Consultation Response from KC, Conservation and Design
2020/90479 Parkwood Methodist Church, Parkwood Road, Longwood, Huddersfield, HD3 4TT
Alterations to convert former church to 12 residential units, formation of parking areas and widen vehicular access (Listed Building within a Conservation Area)
Date Responded: 30/10/20
Responding Officer: Craig McHugh
Responding Ref: HUD 32/363

Revised following receipt of amended plans

- Revised Proposed Site Layout 17-D23-07E
- Revised Plans and Elevations 17-D23-06

Drawn: DRH
 Date: Aug 2018
 Scales: 1:100 @ A1
 Drawing No.: 17-023-06
 Rev: A

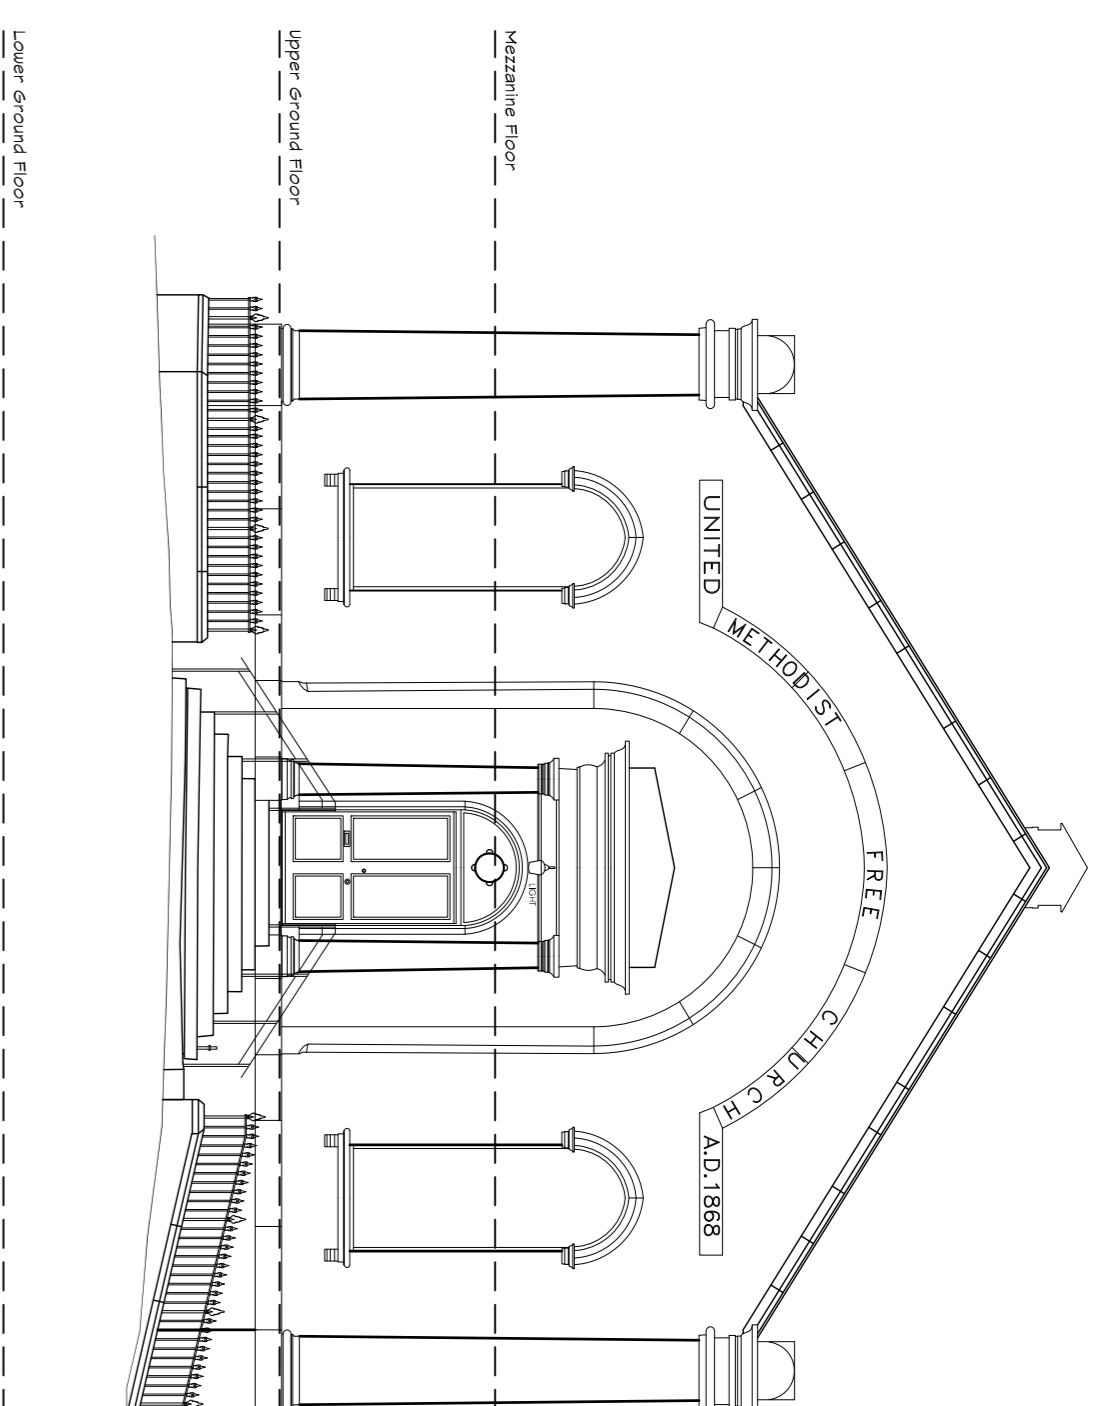
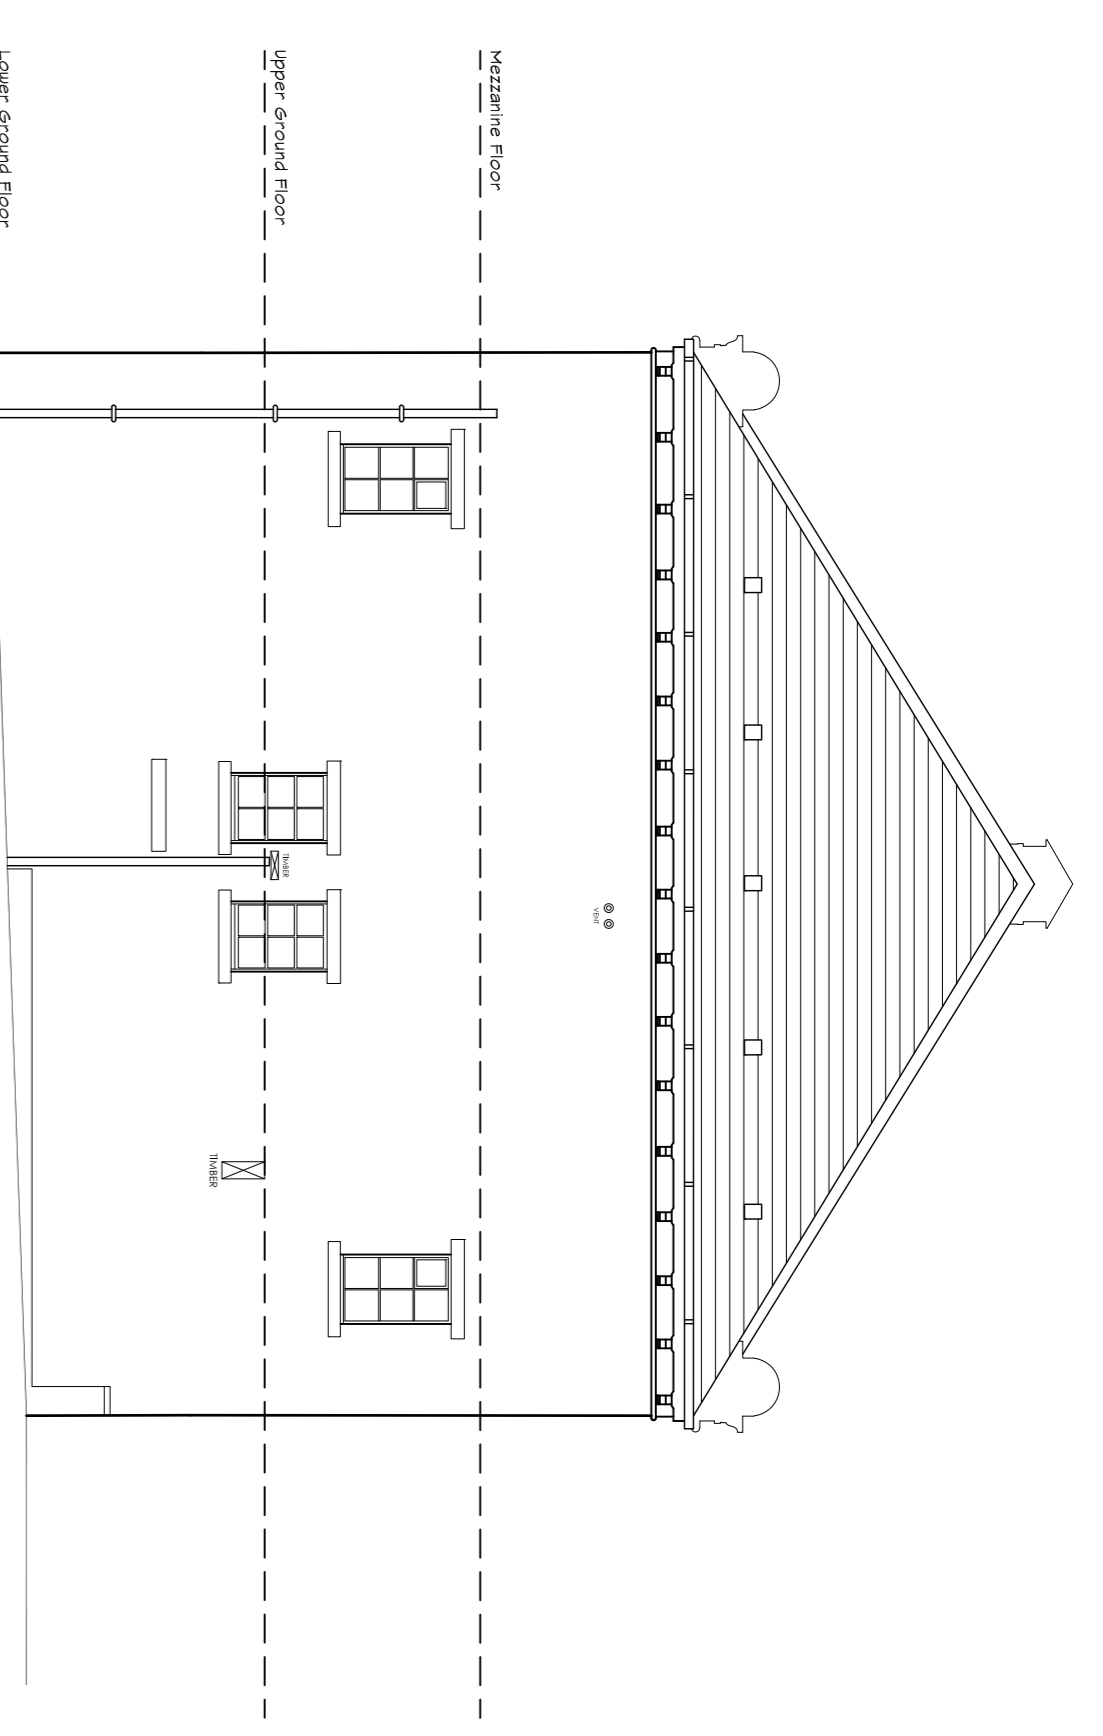
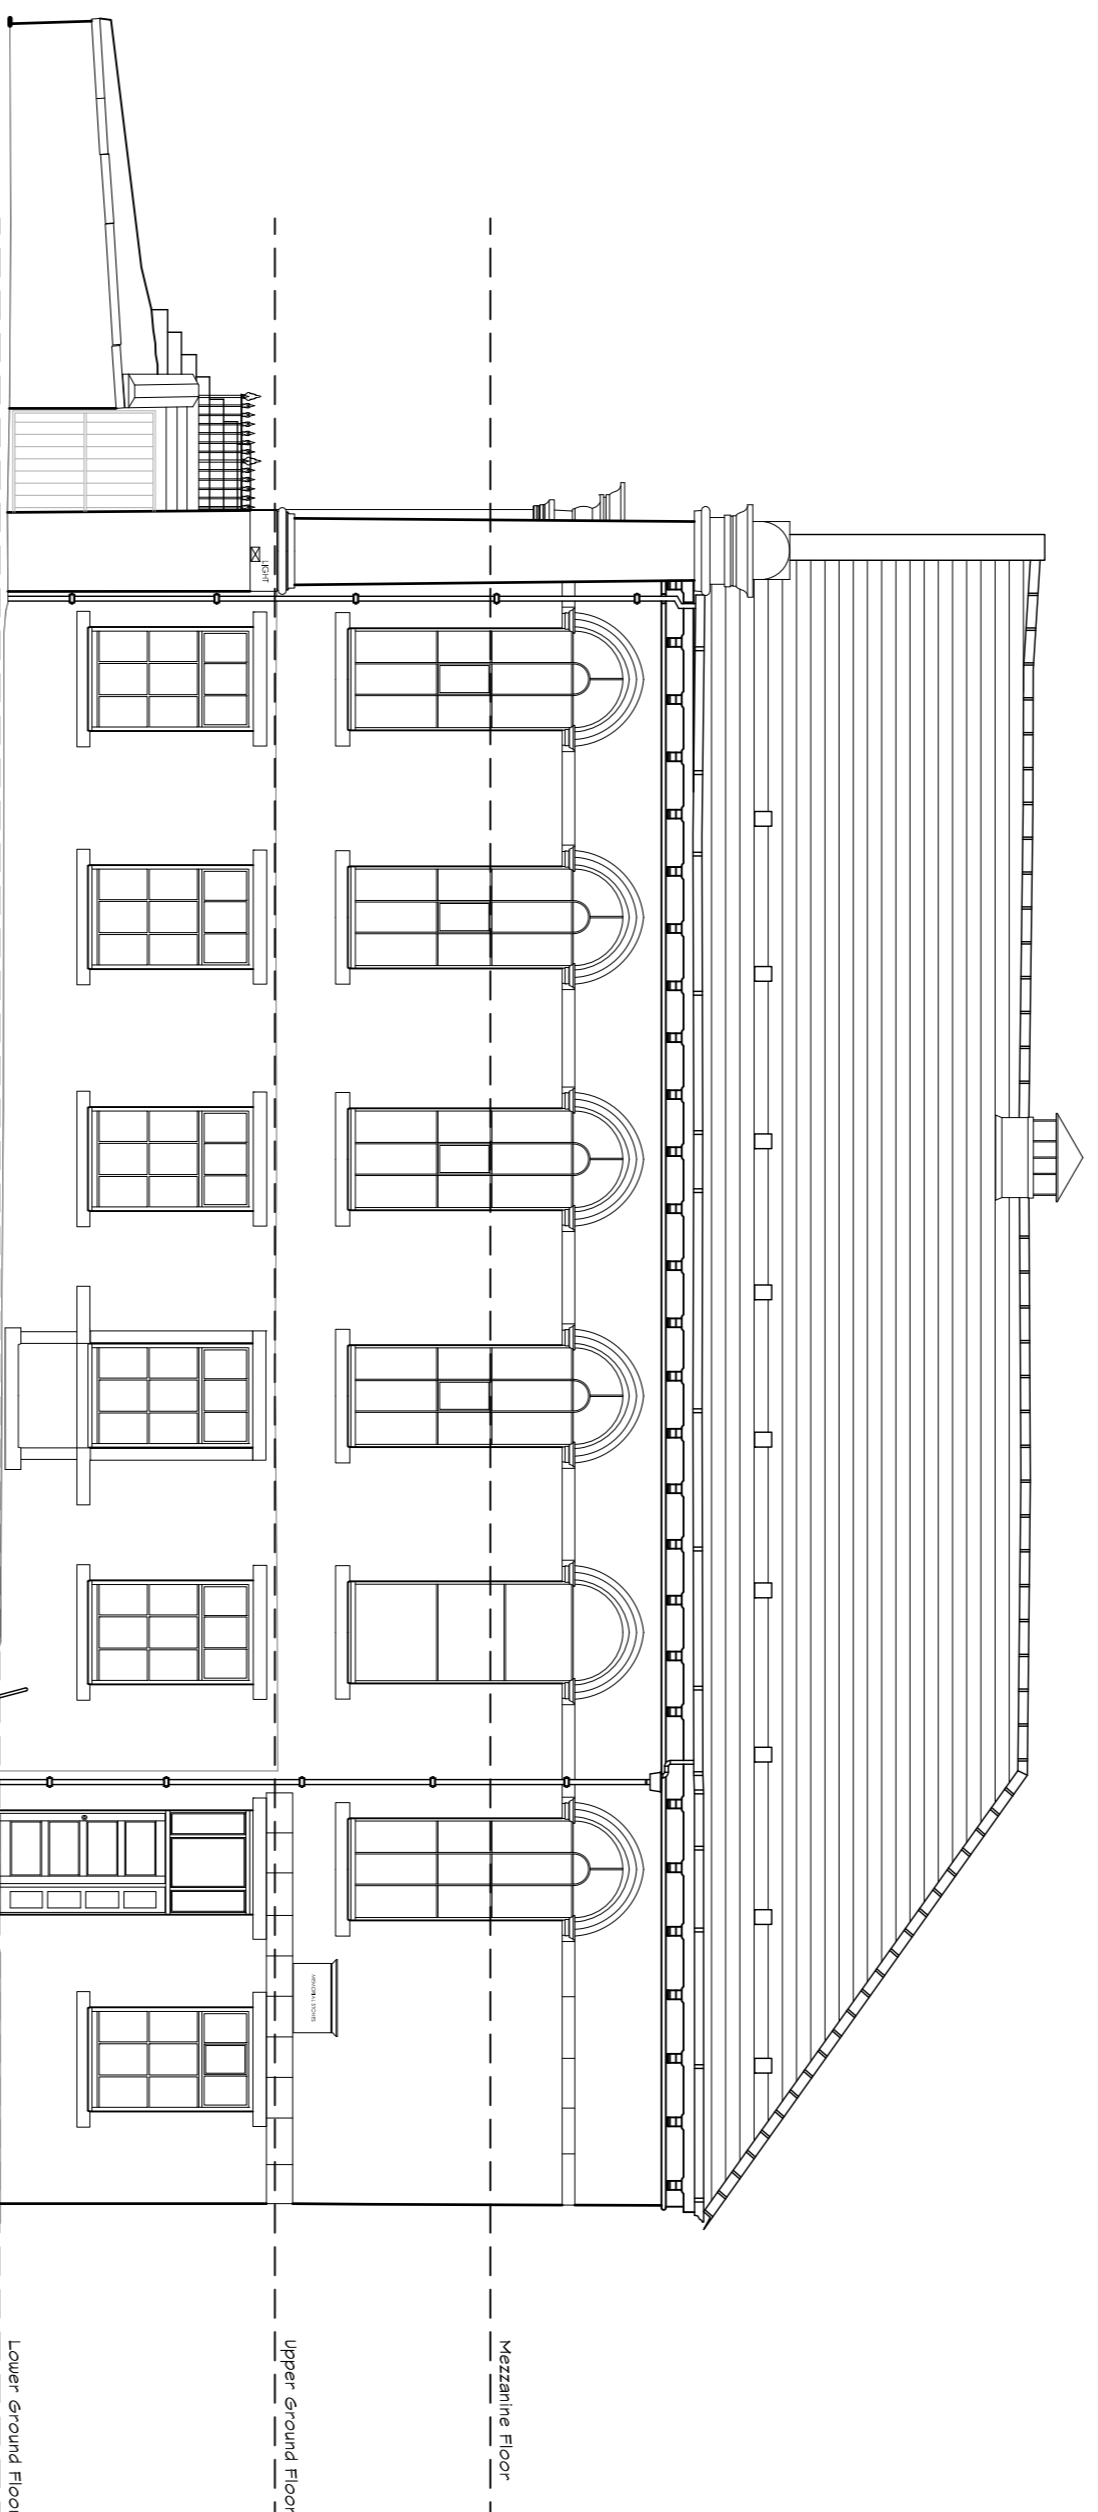
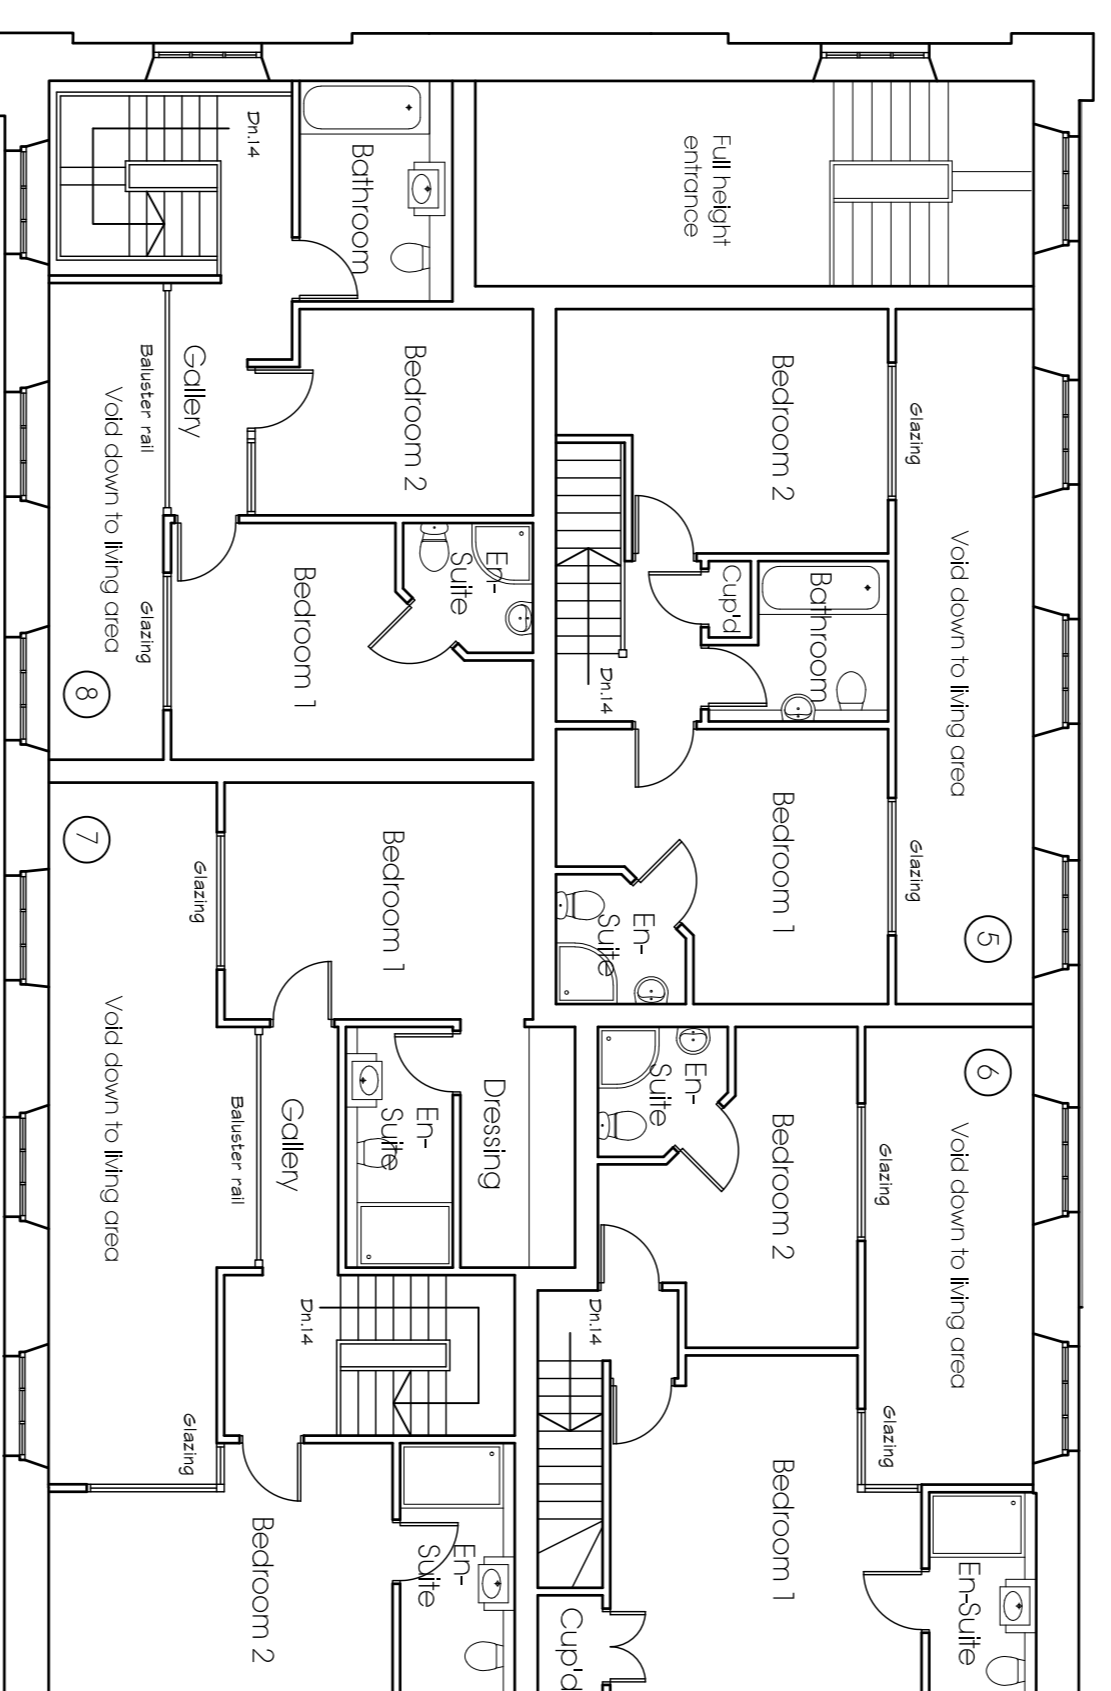
The proposed development would lead to the complete loss of the plan form of the building, with the main body of the church subdivided horizontally and vertically, the loss of all interior joinery and the loss or hiding of its decorative ceiling beams. All windows and doors would be replaced including the memorial windows.

With regards to paragraph 193 of the NPPF, the level of harm would be very high and little short of substantial harm.

A very high level of harm would result from the proposed development. This requires very robust justification including a viability appraisal for this and other less harmful alternative uses or residential conversion schemes, which has still not been provided. The tests of paragraphs 194 and 196 have not been met.

Conservation and Design object to the proposed development on heritage grounds, particularly with regards to paragraphs 193, 194 and 196 of the NPPF. It would cause a very high level of harm to Parkwood Methodist Church and some harm to Longwood Edge Conservation Area, that harm would still be less than substantial harm.

If a residential use is the most appropriate use, then a less intensive conversion should be considered which seeks to:

- retain the memorial windows in situ
- retain interior features wherever possible through a creative approach to subdivision and interior design
- retain some sense of the layout of the building and the volume of the main body of the church
- retain more of the memorial gardens to better preserve the landscape setting of the church and the character and appearance of the conservation area
